**Re: Commercial Building Development
Development Application Submission
BCA Capability Statement**

BCA CAPABILITY REPORT

**3 MURRAY ROSE AVENUE
SYDNEY OLYMPIC PARK**

PROJECT TITLE
3 MURRAY ROSE AVENUE
SYDNEY OLYMPIC PARK
DRAWING TITLE
Basement 03 Plan

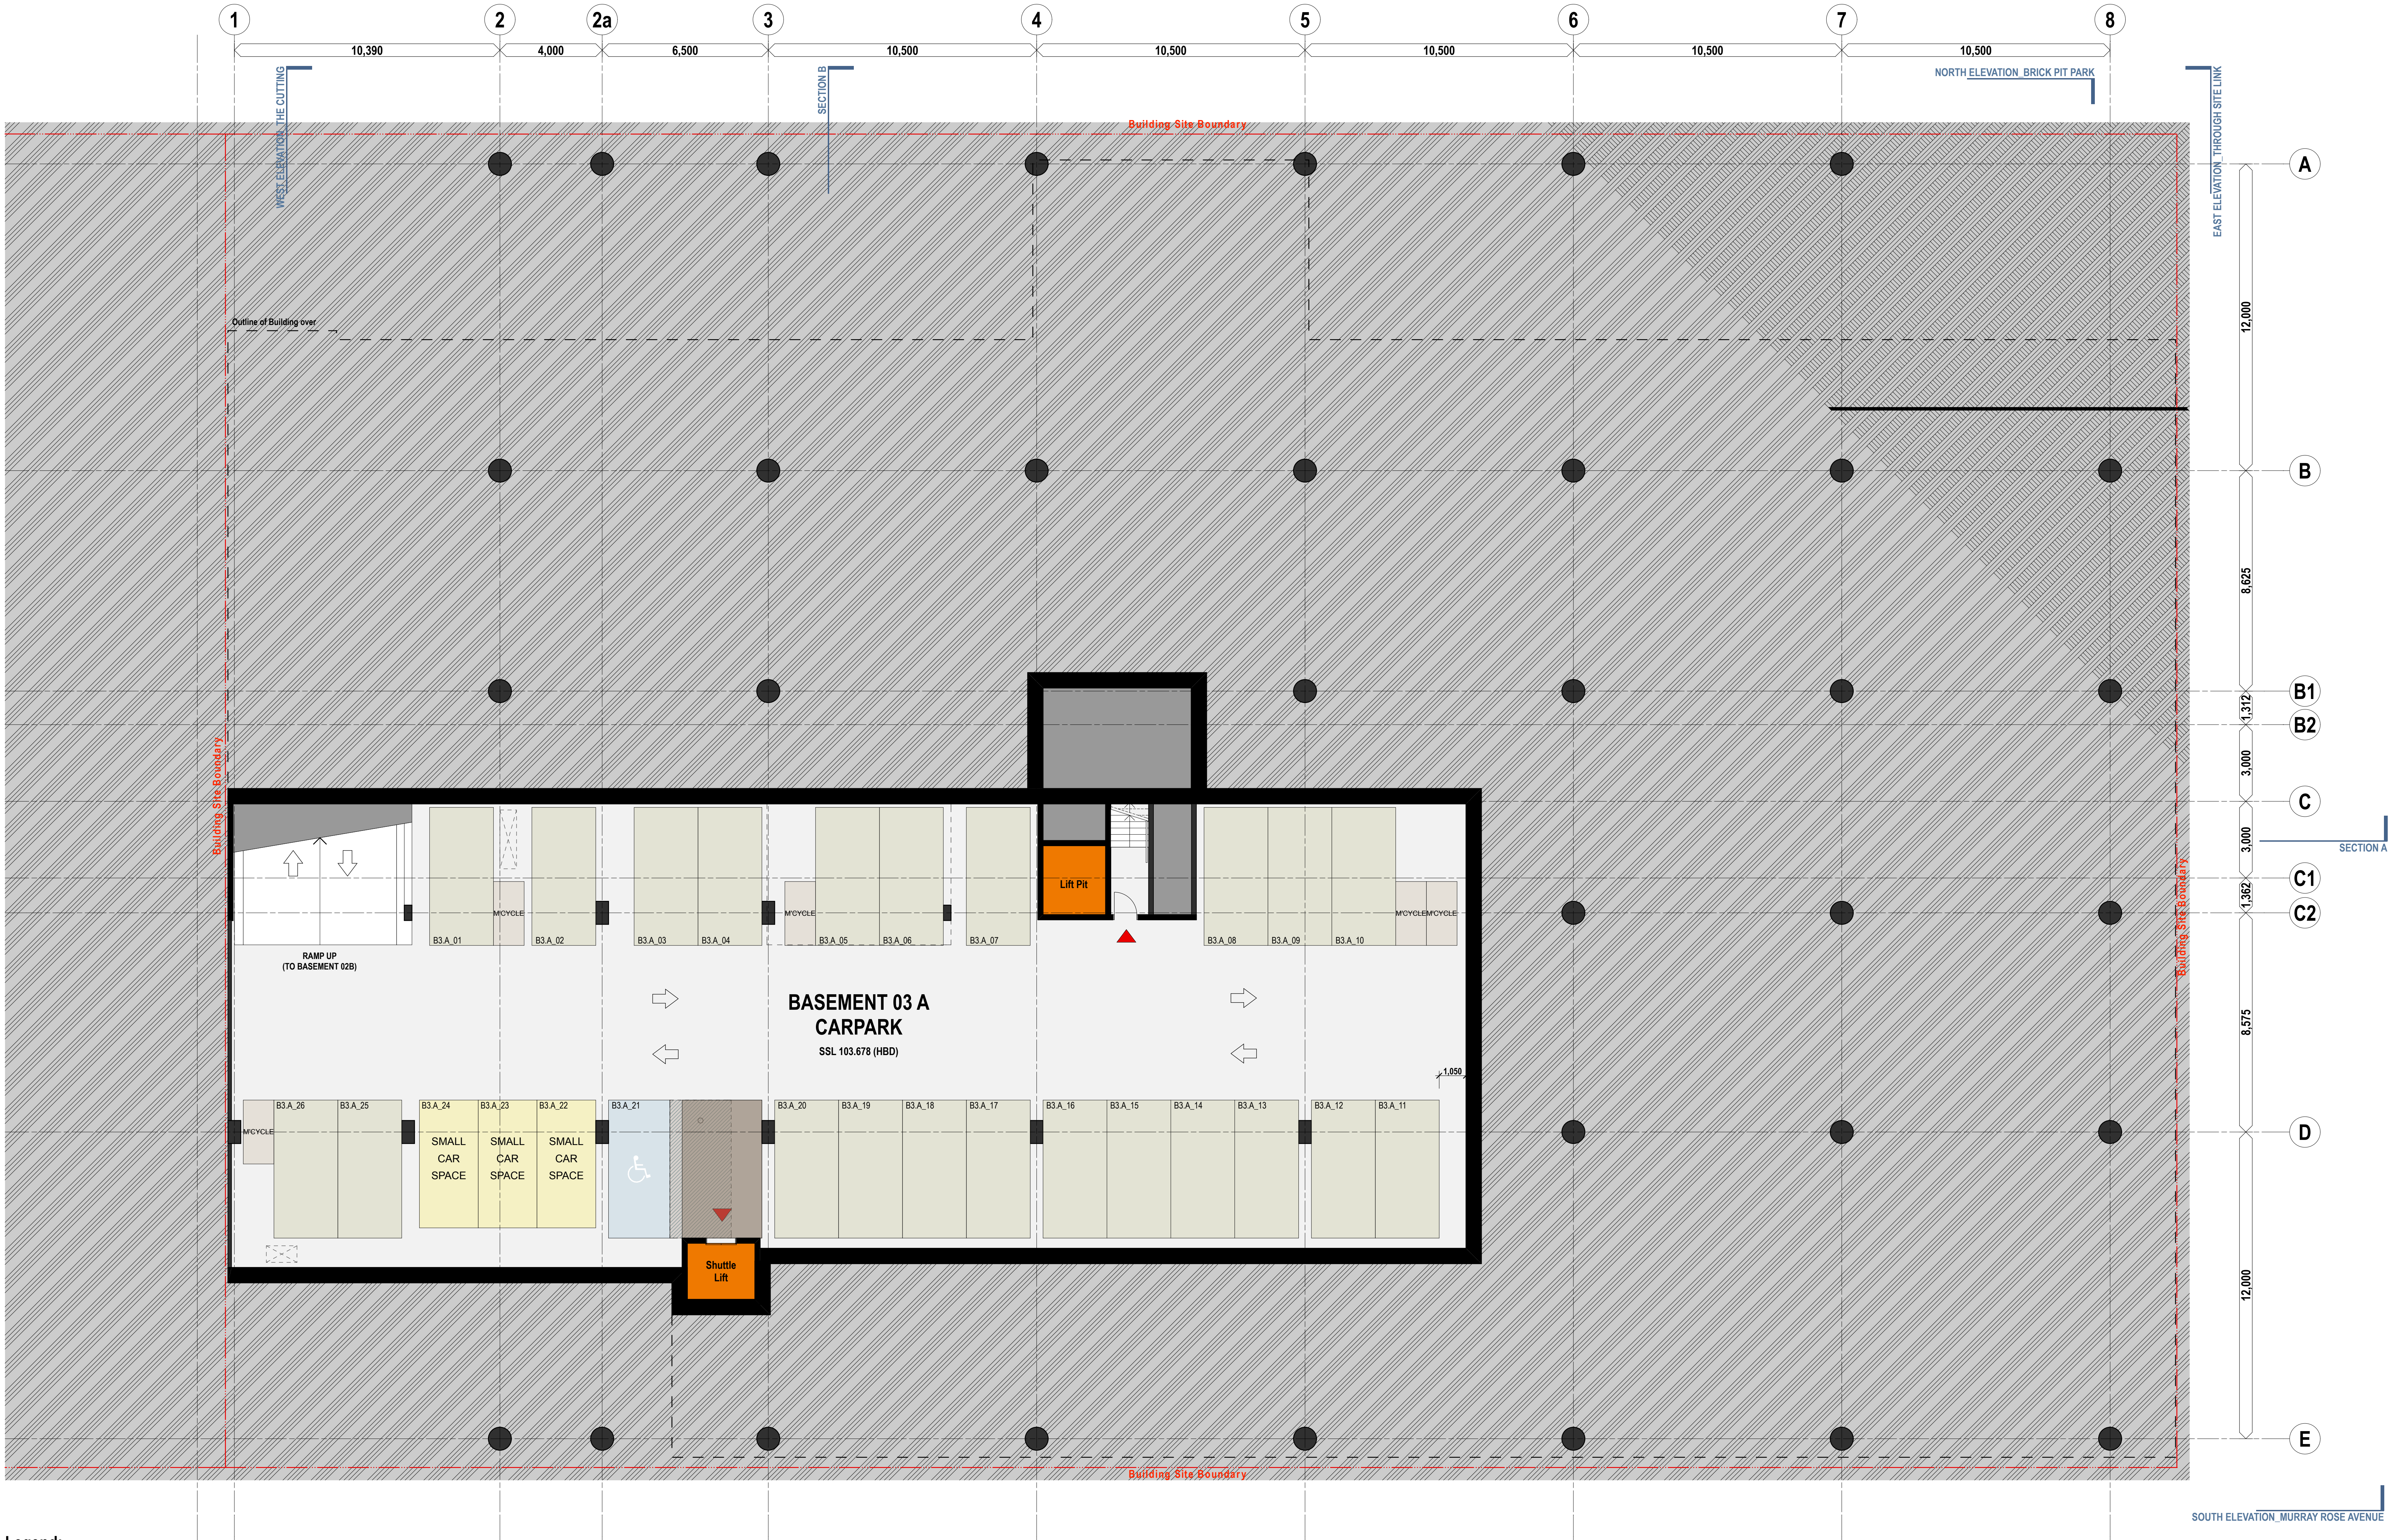
Item	Comment
<i>Number of exits required</i>	<p>The location and of extent of exits generally compliant, a minimum of 2 is required from the basement levels and one from above ground levels</p> <p>In the basement 03A level there is to be an egress path via the vehicle ramp in order to access the alternate exit basement 02B level, in this regard a handrail is required to be provided to the east side of the ramp and the ramp gradient is not to exceed 1:8</p>
<i>Exit travel distances.</i>	<p>The location and extent of exits is generally compliant with the following exceptions:</p> <ul style="list-style-type: none"> • 45m to an exit and 70m between alternate exits to the eastern corner of the basement 02A level. • 42m to an exit from the north corner of basement 02B • 29m to a point in choice in travel from the gas meter room to the basement 01A level <p>The developer has advised it is proposed to address this a fire engineered solution at the construction certificate stage</p> <p>It is noted a similar approach was adopted for the development at 5 Murray Rose Avenue</p>

<p><i>Distance between alternative exits</i></p>	<p>The distance between alternate exits is generally compliant with the following exceptions:</p> <ul style="list-style-type: none"> • the distance between alternate exits in the basement 03A level (using the vehicle ramp) is approximately 70m, 60m being the maximum. • 70m between alternate exits to the eastern corner of the basement 02A level. • 64m between alternate exits from the north and of the lower ground floor B level <p>The developer has advised it is proposed to address this a fire engineered solution at the construction certificate stage</p>
<p><i>Travel via fire isolated exits</i></p>	<p>Exits are formed by fire isolated exits are rising and descending flight within the same shaft converging at the lower ground floor level with the exists discharging dock entry location. The rising and descending flights are not smoke separated to the extent required at the level of convergence, in this regard the developer has advised it is proposed to address this a fire engineered solution at the construction certificate stage</p>
